From: Thomas Callaway
Sent: 17 June 2015 15:34
To: Planning.Responses
Subject: RE: Planning Consultation on: BN/13/15/PL

APPLICATION **BN/13/15/PL**

Site Address: Saxons 33 Hill Lane Barnham PO22 0BL

Description of Works: Demolition of existing shed/garage & erection of 1 No.
 detached dwelling.

Proposed Site Block Plan @ 1:500

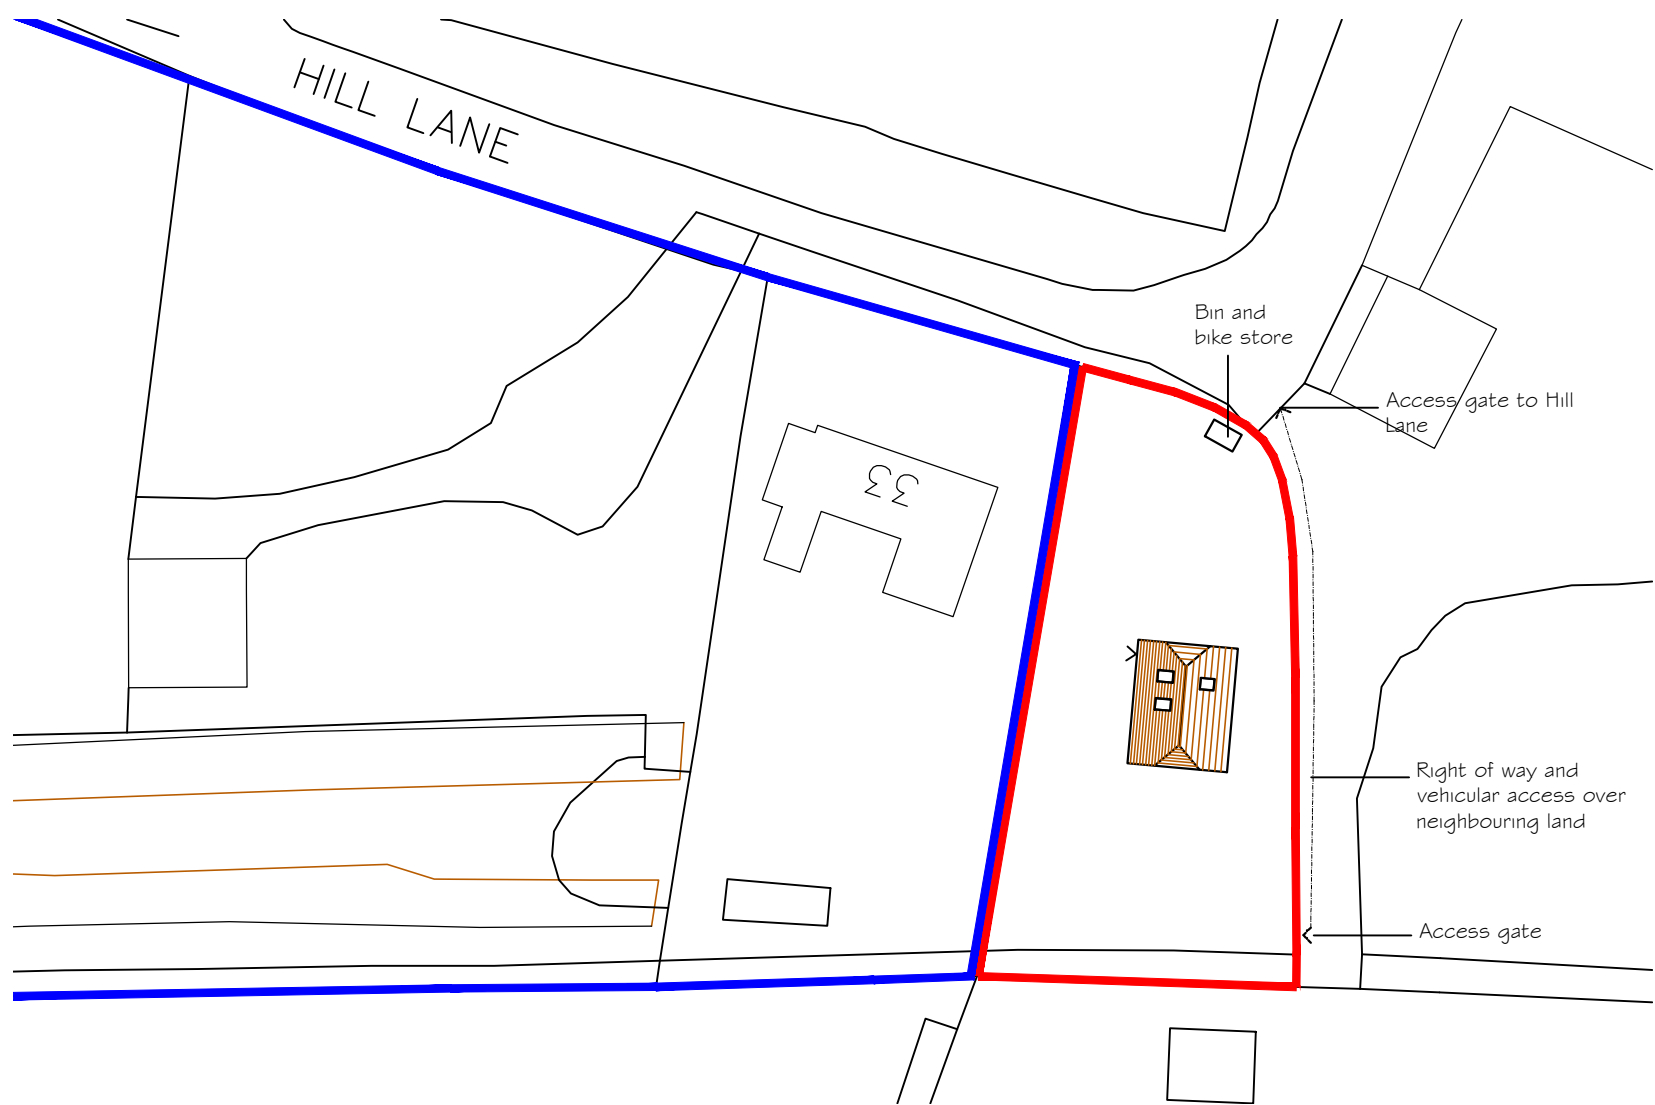
A culverted ordinary watercourse runs through number 33 approximately along the line of the proposed new boundary. The condition of this watercourse must be maintained, and a three metre easement is required between the watercourse and new buildings. This means that before the layout is approved, the exact location of the watercourse must be determined. Also, the position of any boundary treatment (fencing, hedges etc) must be well away from the watercourse to prevent damage (roots, fence post stakes) and allow access for maintenance. Therefore a plan should be provided showing the precise route of the watercourse, boundary and new building, and also details of the nature of the boundary.

A developer upstream is in discussions with us regarding upgrading the surface water culvert running along the approximate proposed boundary between the new building and number 33. Discussions are at an early stage, however when the owner of number 33 was consulted by our engineer and the developer approximately a month ago, no mention was made of this proposed development.
